Since this SP review is just for approval of the early/overlot grading, please remove curb and gutter, roads, buildings, and utilities (unless installation of utilities is also requested with early grading, SWMP states "no.").

SHEET **2** OF **7**

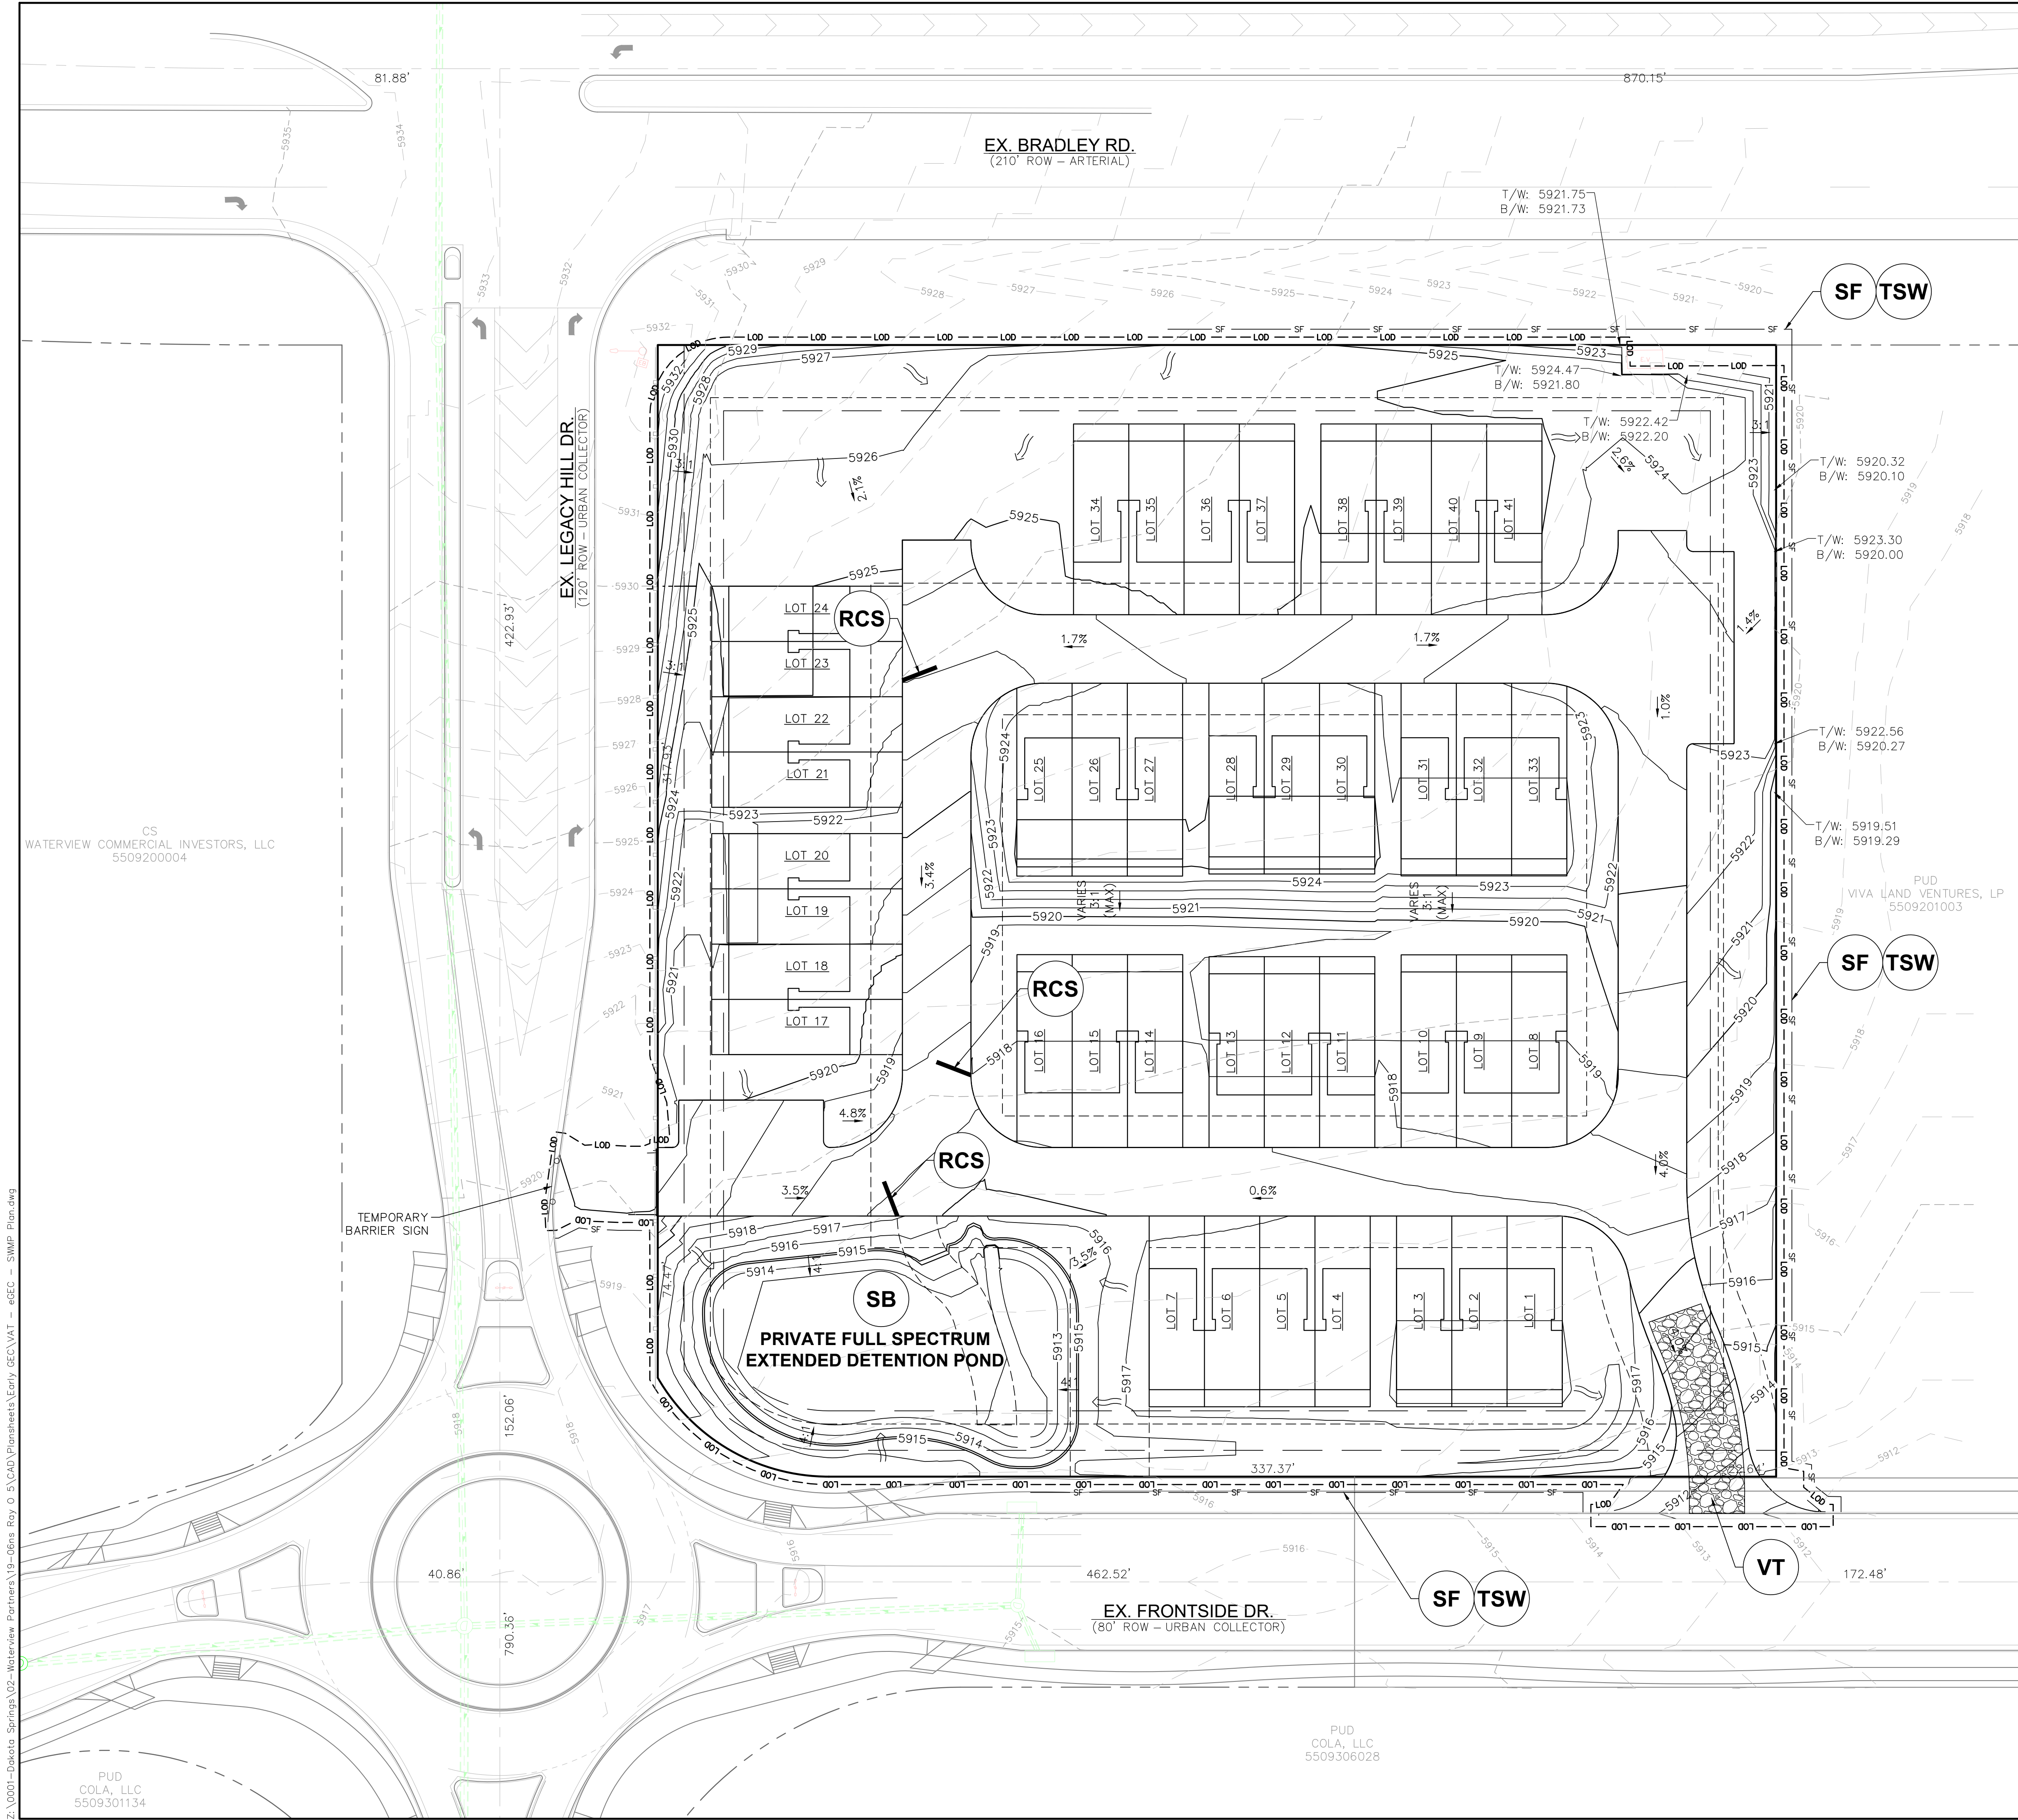
- Item b - label adjacent properties/parcels
- Item d - add a Legend
- Item e - show property lines
- Items H and M. If "limits of disturbance" and "construction boundary" are the same, change to "limits of construction/disturbance" or otherwise show as separate line types for each on the legend and figure.
- Item i - add a note about existing vegetation
- Item p - show areas of cut/fill.
- Item s - show drainage flow arrows
- Item v - label all BMPs by phase
- Item w - see comment to the left.

Add a general note: all areas to be vegetated with permanent seeding should also be temporary stabilized via track rolling or some other means.

And show location of temp seeding (2.46ac according to FAE Form).

Be sure to show all grading with LOD/LOC

GEC Checklist Item W. Provide construction fencing, barricades, and/or signage at access points not to be used for construction.

Provide a stabilized access ramp that is a minimum of 15ft wide and no greater than 12% slope, in accordance with DCMv1, Chap 11.2.2.

Provide a County access easement for pond.

Per DCMv1 Chap 11.3.3, adjust pond design to include a min. width of 12ft at top of embankment.

Show as a TSB in the early grading (initial/interim) condition. And provide temp conveyance (if needed) like temp swales to convey all early grading runoff to the TSB.

Typical comment for TSBs: Provide details of temporary sediment basin including riser pipe diameter and perforation sizing, number of rows of holes, required volume, location of outlet pipe and spillway, and tributary area to the sediment basin. And provide contours for sediment basin.

**EC-9 Rough Cut Street Control (RCS)**

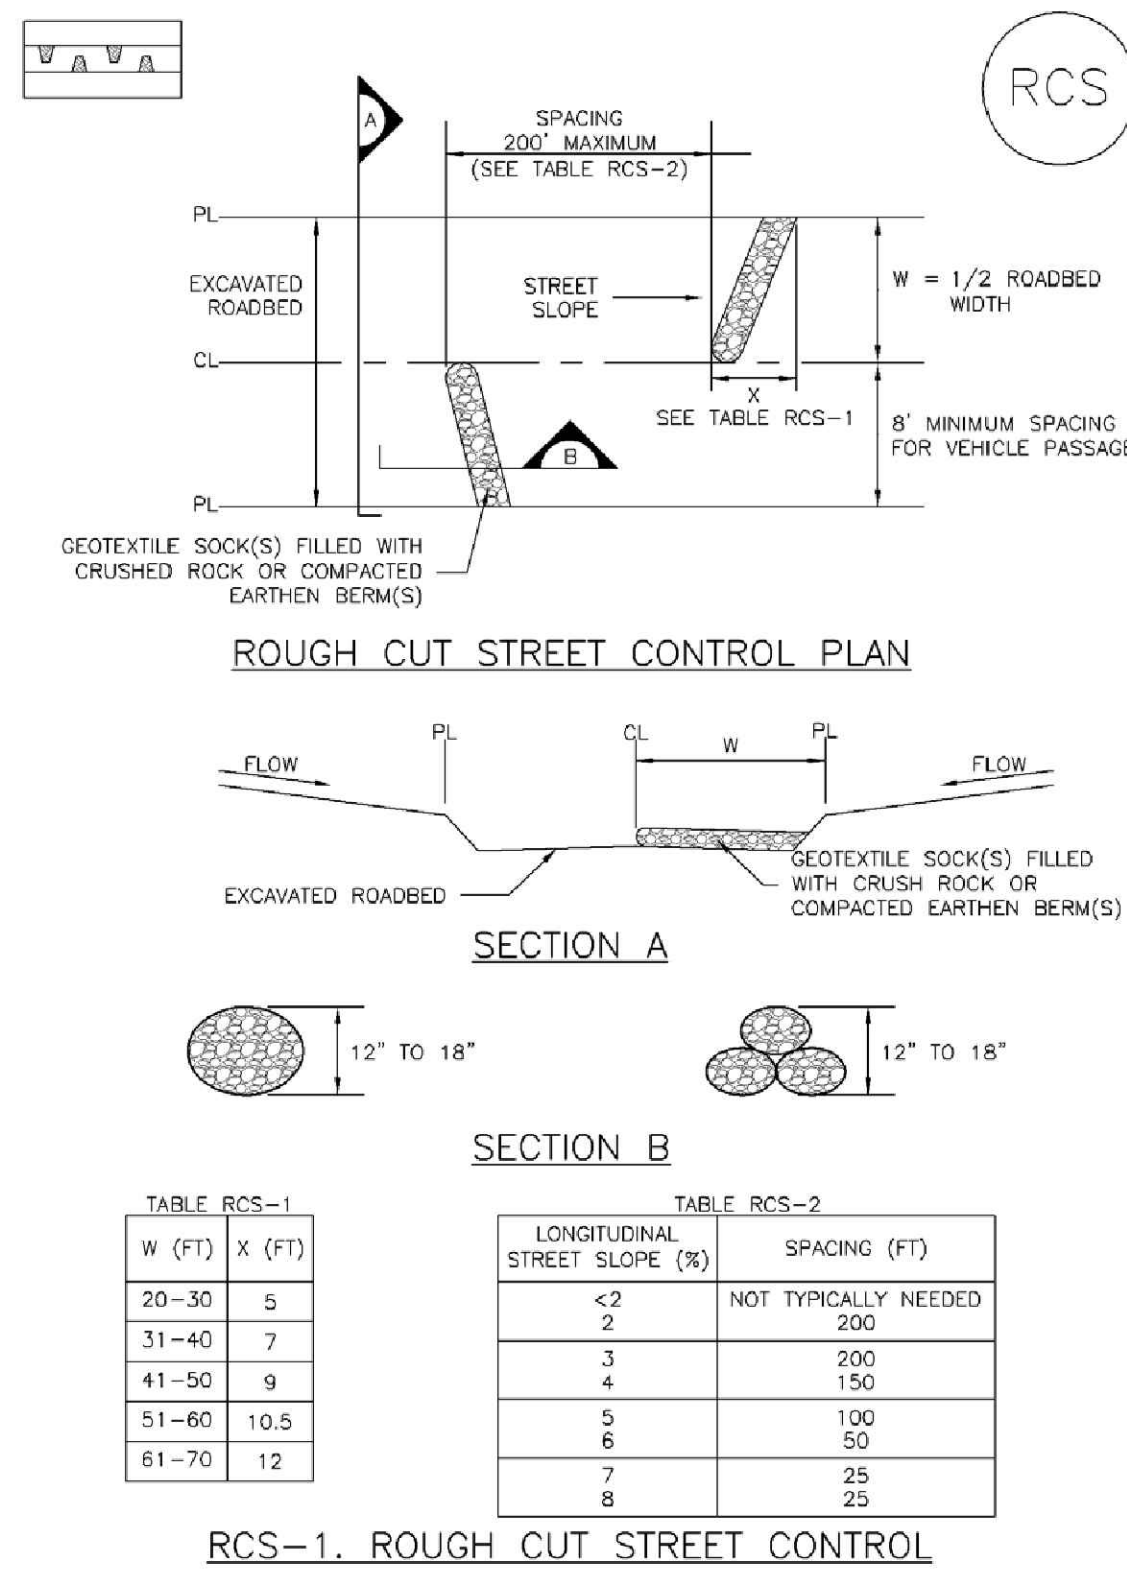
And provide an access road detail/cross section, including stone sizing and gradation. Show cross slope at 2%.
